From: [Public Health Inspectors](#)
To: [Zach Torrance-Smith](#)
Subject: RE: BL-24-00004 Lichota - Notice of Application
Date: Thursday, May 16, 2024 10:36:45 AM

Please review the following Boundary Line Adjustment Application: BL-24-00004 Lichota. Any comments need to be received by **5 PM on May 15, 2024**.

**LICHOTA SITE PLAN
530 ROZA VIEW DRIVE**

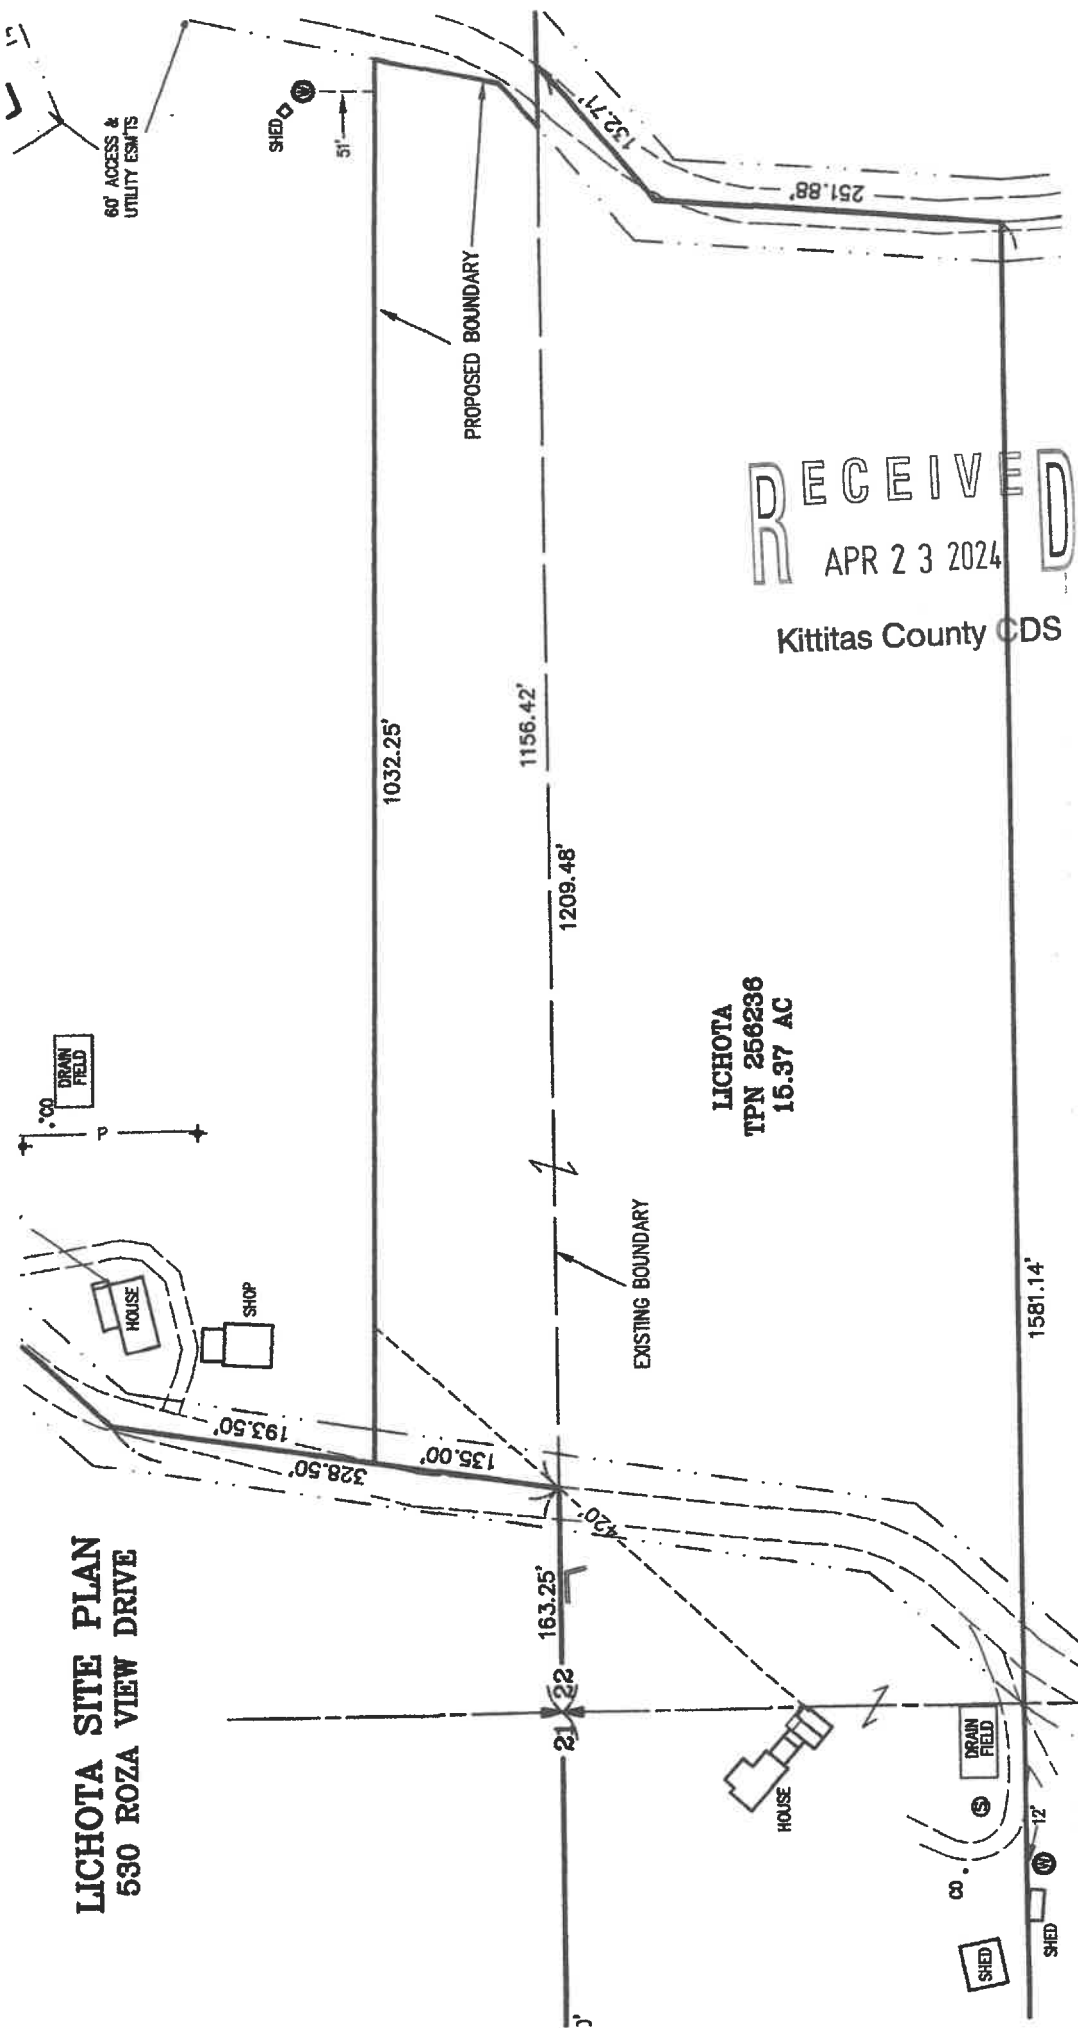
After review of this proposed boundary line adjustment I have a question as to where the well is located for PN 256236. There is a well located across the property line about 12 feet on the parcel to the south but that is the only well shown in the near vicinity of the home and drainfield on this parcel. If it is a shared well, that would be helpful information.
